12364 - North Penrith Stage 2D Development Application

RESPONSE TO AGENCY SUBMISSIONS

HOWELL PARK CONCEPT PLAN

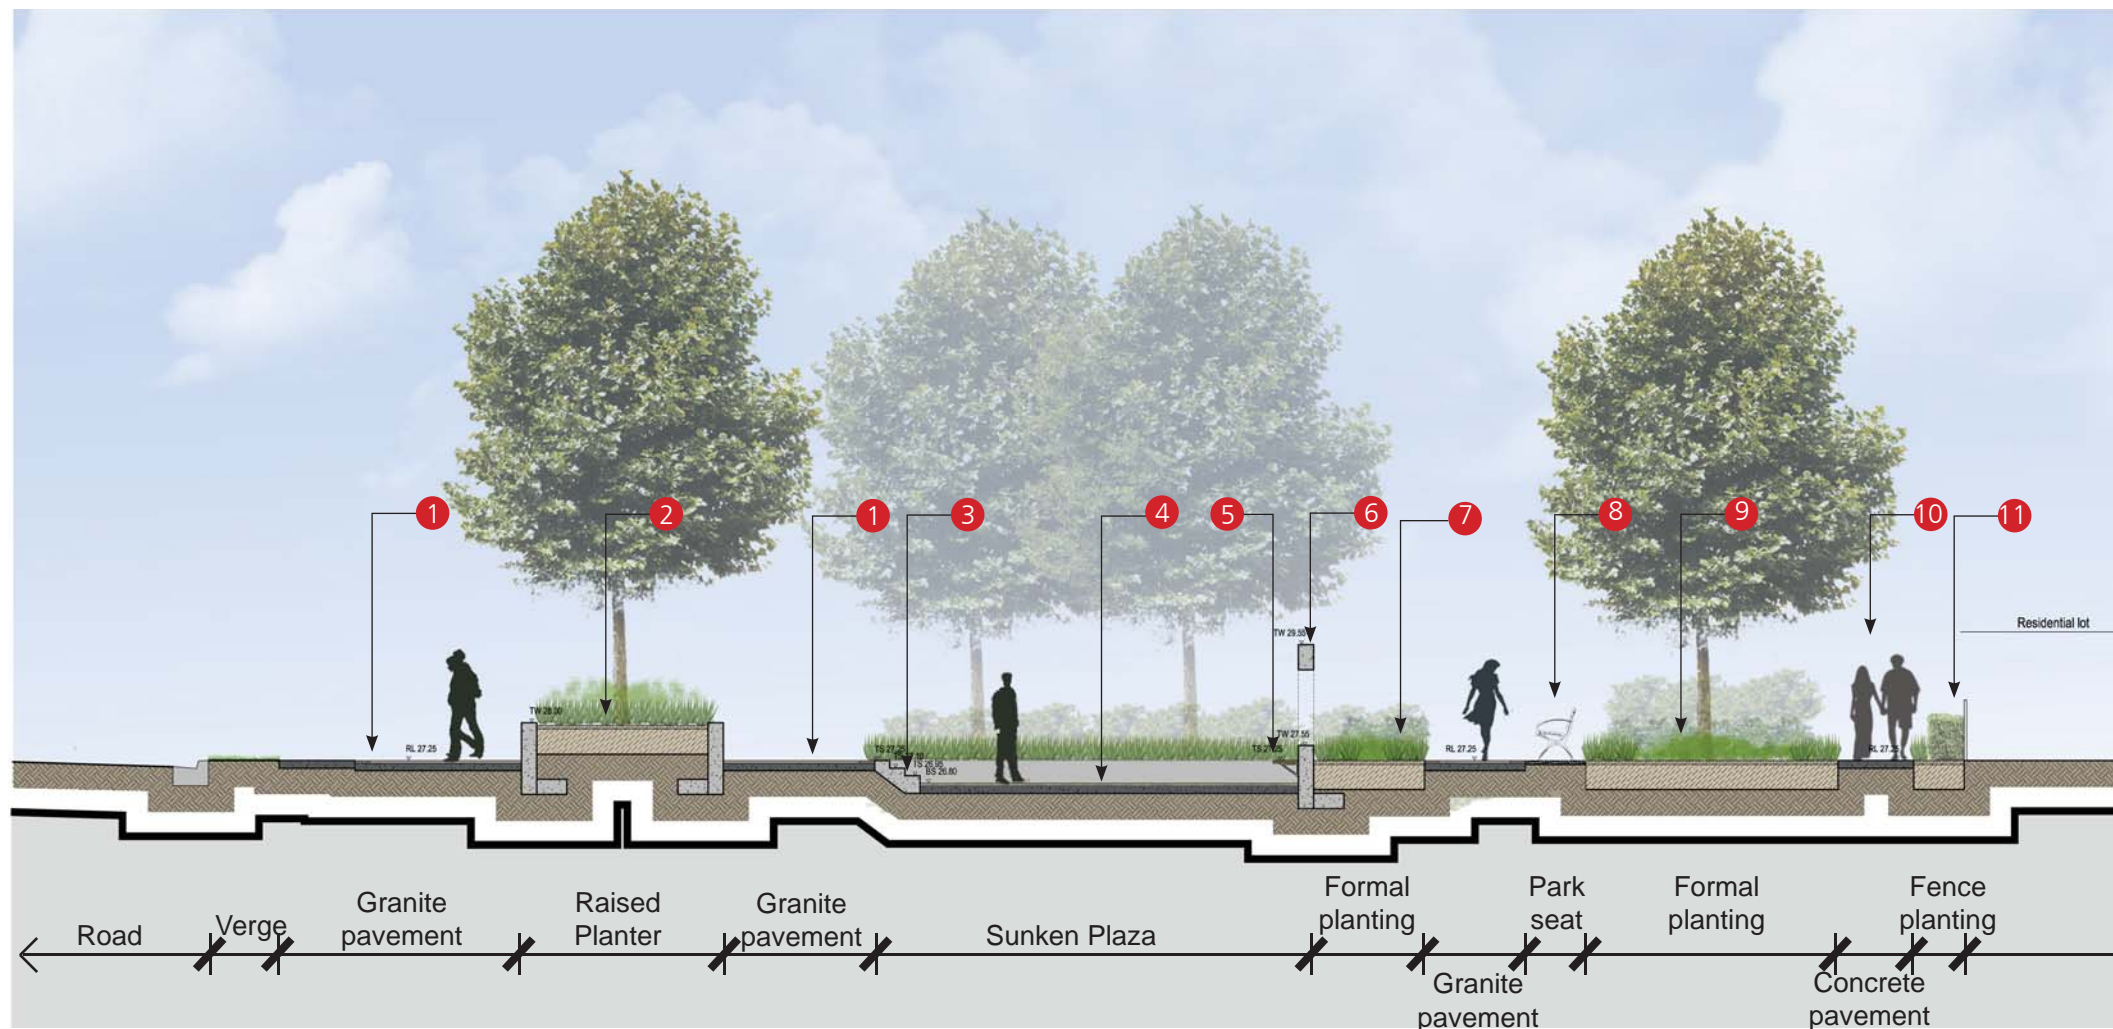
<ul style="list-style-type: none"> All vegetation throughout Howell Park shall have high canopies or be low in height to maximise surveillance. 	<ul style="list-style-type: none"> Noted. To be address in construction certificate.
<ul style="list-style-type: none"> The sunken plaza is anticipated to become a popular congregation area after hours. Good sight lines to the plaza from all sides of the park will be important to provide opportunities for natural surveillance. 	<ul style="list-style-type: none"> Noted. To be address in construction certificate.
<ul style="list-style-type: none"> Howell Park closely bounds residential lots on one side. Access control measures and clear boundaries will be important to restrict unauthorised access. 	<ul style="list-style-type: none"> Noted. This is a detailed design issue for the future dwellings and will be addressed as part of future housing development applications.

LOCAL STREET (SECTION 1)
EMPIRE CIRCUIT

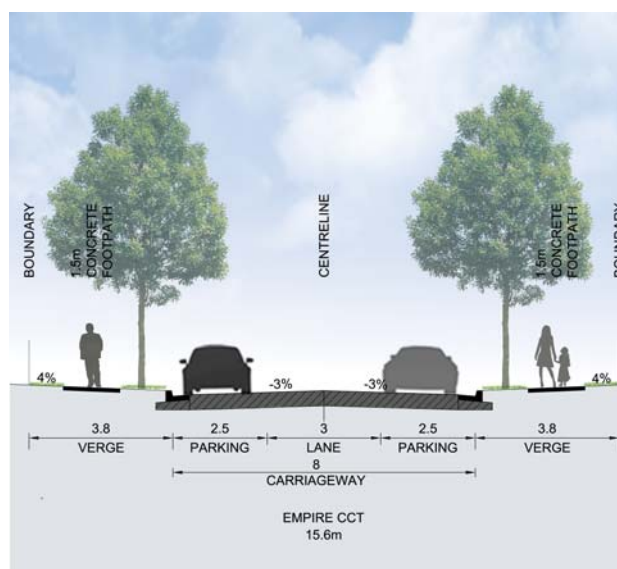
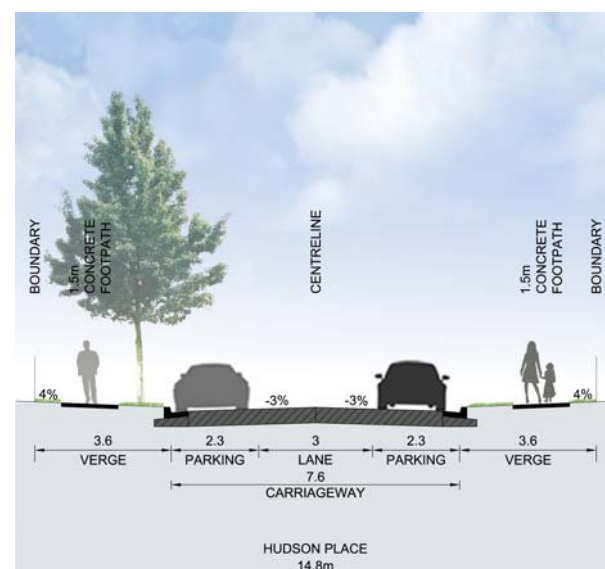
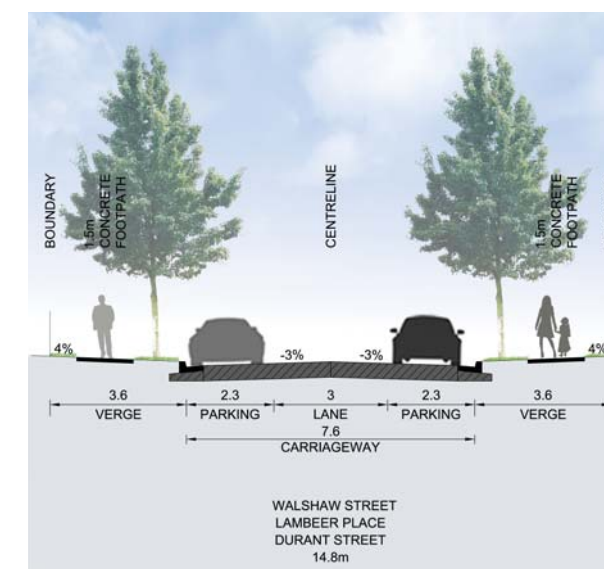
<p>costs for a period of 36 months. The Maintenance Schedule indicates that the ongoing costs to Council will be minimal post handover. Council has previously reviewed the Schedule and advised that the costings are acceptable.</p>
<ul style="list-style-type: none"> Street cross sections are inconsistent with Council standards. Council's standard is 1.5m, however this path in a 3.6m verge means there is insufficient space for street trees. Also, there are both 3.8m and 3.9m verge widths. 	<ul style="list-style-type: none"> The proposed street cross sections are consistent with those approved under the Concept Plan Approval. There are only minor adjustments where new street cross sections need to integrate with existing conditions (such as on Thornton Drive and on Combewood Avenue at the interface with the commuter car park). 1.5m footpaths are provided in all locations, and street trees are still provided within the 3.6 verge.
